# A12 Chelmsford to A120 widening scheme

## 9.41 Applicant's Responses to ExQ2

**Applicant's Responses to ExQ2**

<b>Regulation Number</b>	Rule 8(1)(c)(ii)
<b>Planning Inspectorate Scheme Reference</b>	TR010060
<b>Application Document Reference</b>	TR010060/EXAM/9.41
<b>Author</b>	A12 Project Team and National Highways

FIGURE 6.10

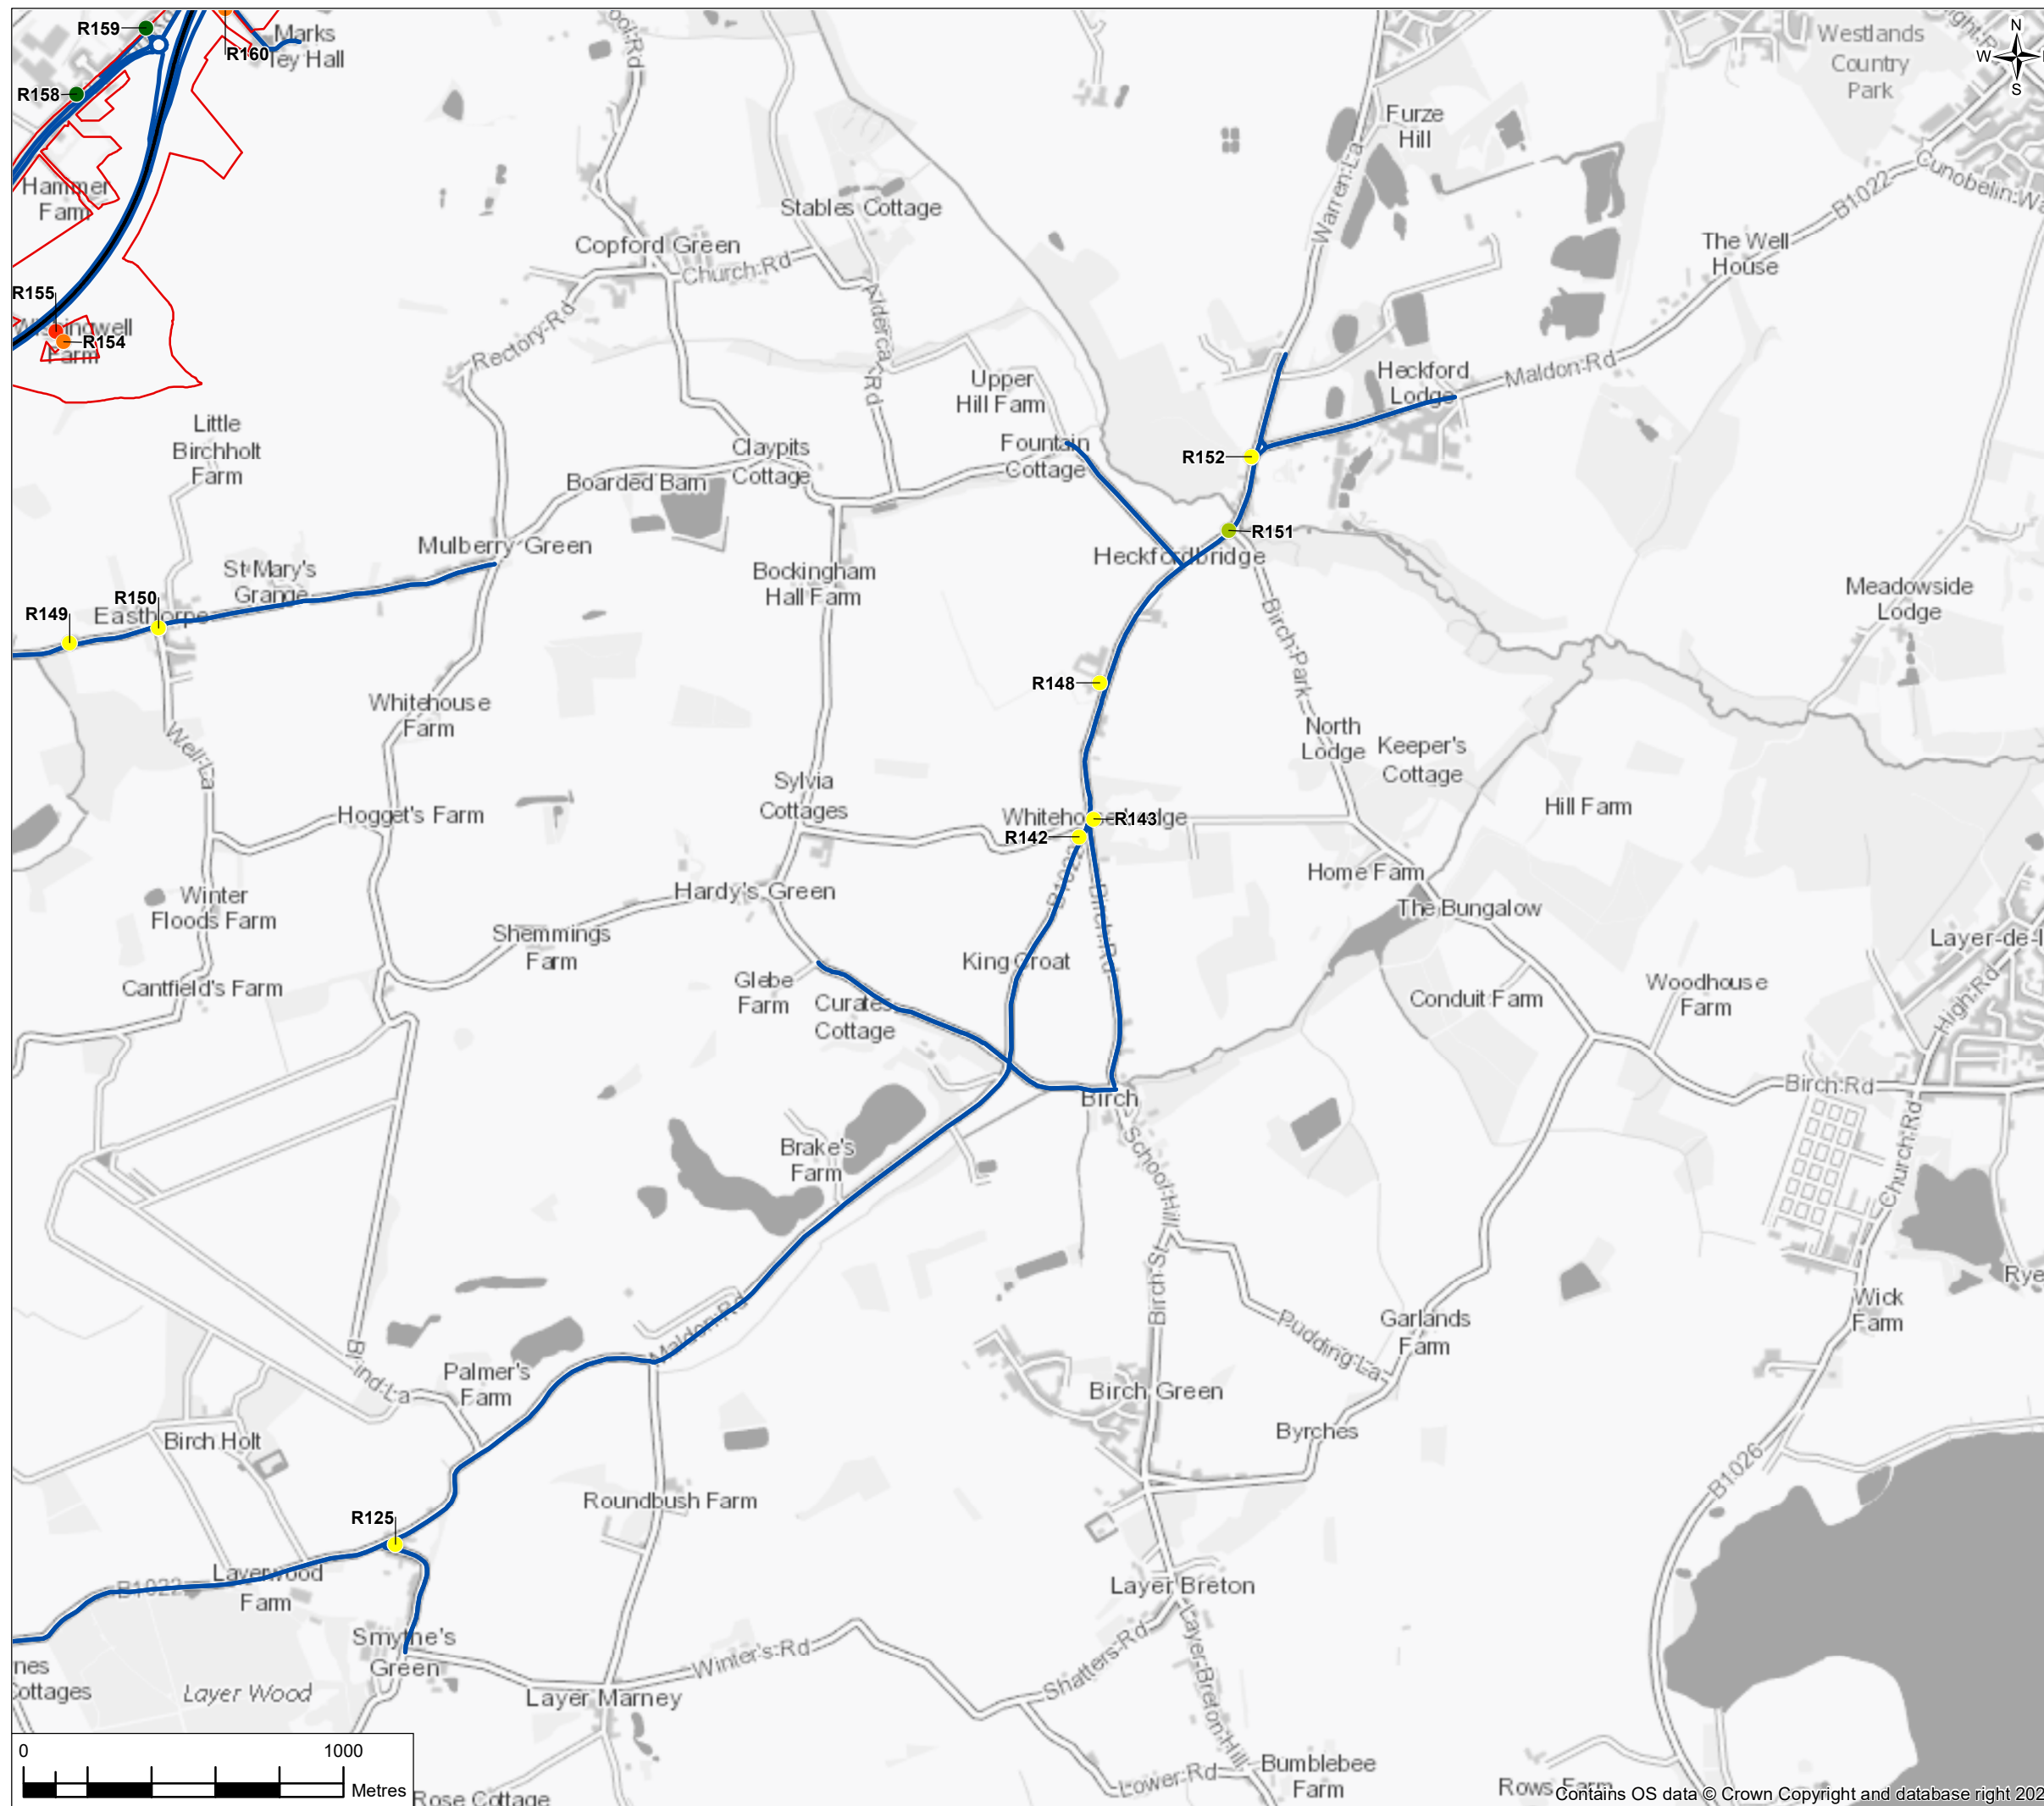
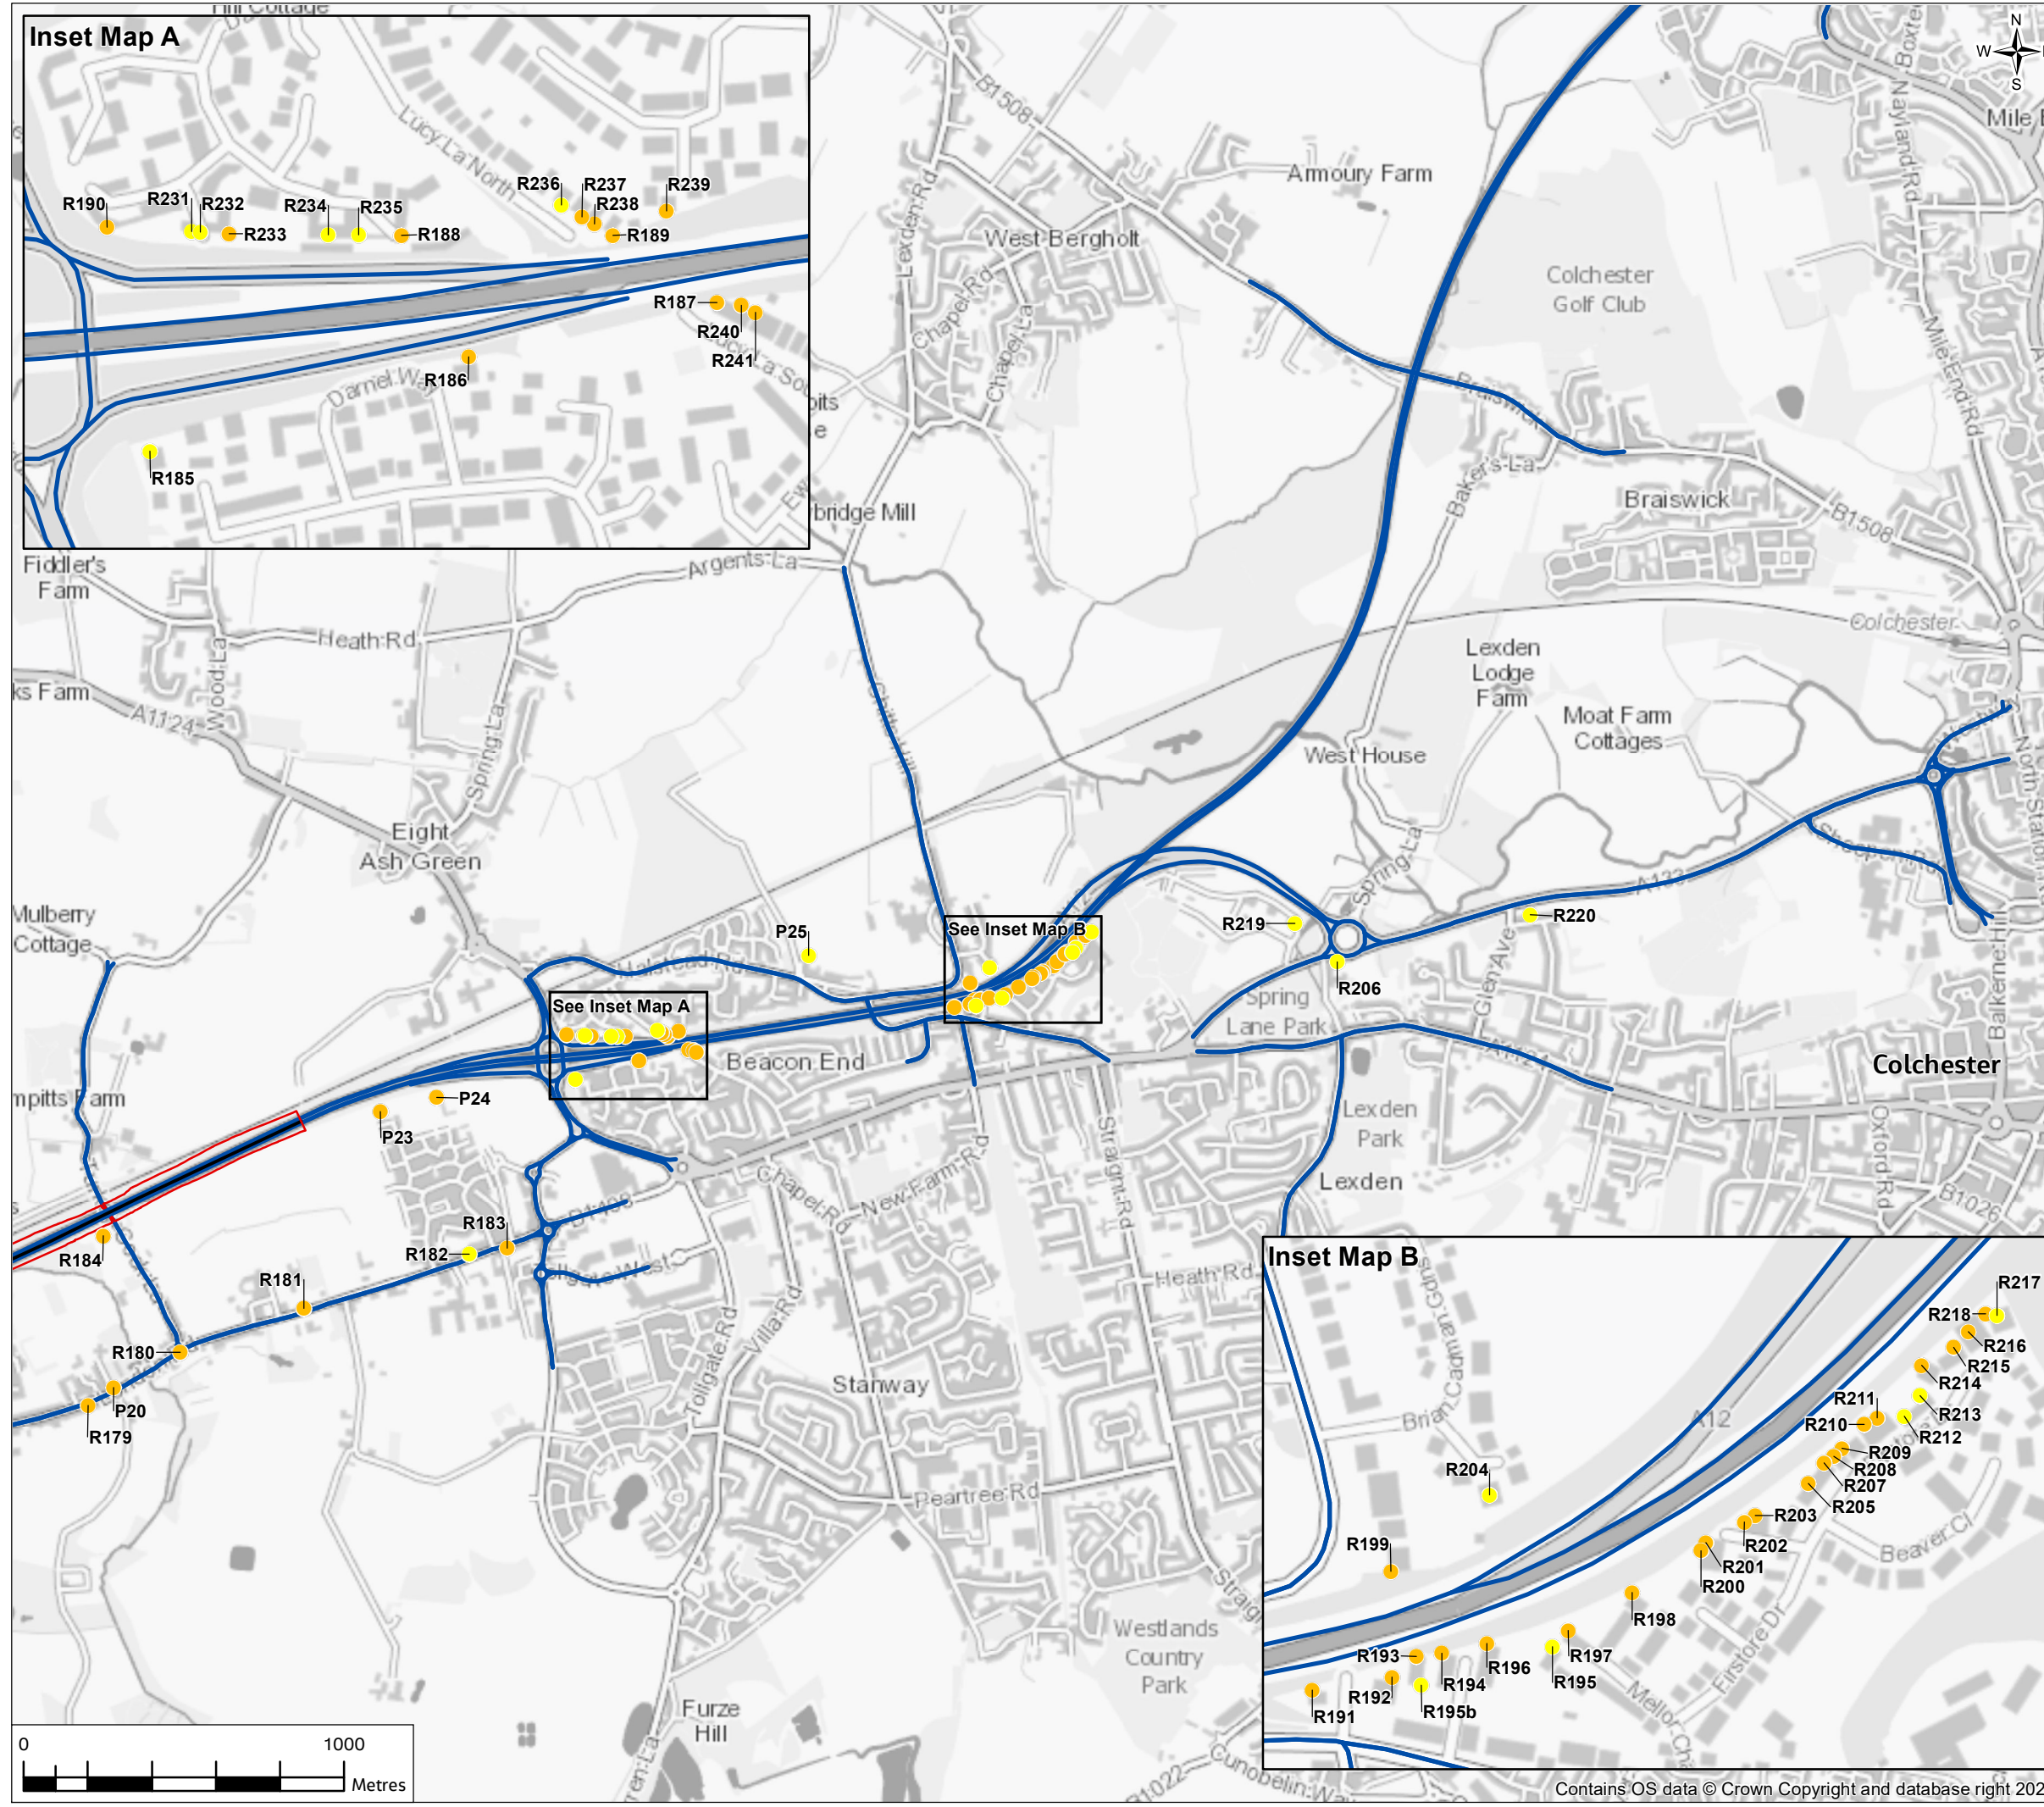
ES Chapter 6 [APP-073], Air Quality, identifies that during the peak construction year, two human health receptors (R189 and R193) were found to be at risk of exceeding the annual mean NO<sub>2</sub> Air Quality Objectives (AQO). These receptors were also shown to exceed the threshold once the Proposed Development is operational. Given that in both instances levels are predicted to exceed AQO during both construction and operation, notwithstanding details already submitted, please can the Applicant provide more justification as to why the need for an Air Quality Management Area (AQMA) and associated Project Air Quality Action Plan (PAQAP) is not triggered at these locations.

The air quality modelling predicted exceedance of the NO<sub>2</sub> annual AQO at two human health receptors (residential properties referenced as R189 and R193) during the peak construction year 2025 and in the opening year 2027 both with and without the proposed scheme. The increase in NO<sub>2</sub> was classed as imperceptible in the construction year (i.e. <0.4µg/m<sup>3</sup>) and small in the opening year (i.e. >0.4µg/m<sup>3</sup> and <2.0µg/m<sup>3</sup>) (see Chapter 6 Air Quality Table 6.16 in the Environmental Statement [APP-073]). A third human health receptor R225 was also found to exceed the NO<sub>2</sub> AQO in the opening year for the with scheme scenario but not in the no scheme scenario. In this case the increase in NO<sub>2</sub> concentration was classed as medium (i.e. >2.0µg/m<sup>3</sup> and <4.0µg/m<sup>3</sup>). Further information on these assessments is discussed within the Environmental Statement Chapter 6: Air Quality Assessment [APP-073] Section 6.9.

A conclusion of no significant effect was reached in relation to the impact of the proposed scheme at the project level. This conclusion applied the approach set out in DMRB LA 105 Table 2.92 whereby, for a given magnitude in predicted increase in NO<sub>2</sub> concentration, no significant effect at a project level was determined on the basis of the number of individual properties suffering a worsening of an existing exceedance and creation of a new exceedance. The numbers of receptors with medium and small exceedances predicted for the proposed scheme are well within the ranges provided in DMRB LA 105 Table 2.92.

For the proposed scheme, the Applicant considers that future exceedances are unlikely due to the conservative nature of the air quality model. In other words, the Applicant considers that the air quality results are over-estimating future NO<sub>2</sub> concentrations based on the uplift applied via the Long Term Trends Gap Analysis (LTTE6) in accordance with the DMRB LA 105. This analysis is discussed further in Section 1.15 of the ES Appendix 6.3: Dispersion Modelling Process [APP-102].

The Applicant considers that the most appropriate way forward would be to monitor NO<sub>2</sub> at the three locations to determine the actual NO<sub>2</sub> concentrations and compare them with the Annual Mean AQO of 40µg/m<sup>3</sup>. If, as expected, the NO<sub>2</sub> concentrations are below the AQO, there would be no need to declare an AQMA. Ideally the NO<sub>2</sub> monitoring should be conducted over 12 months to compare the results against the Annual Mean NO<sub>2</sub> AQO. However, monitoring over a shorter period (i.e. less than nine months) is also possible given that the results can still be annualised to obtain the annual monitored NO<sub>2</sub> concentration.
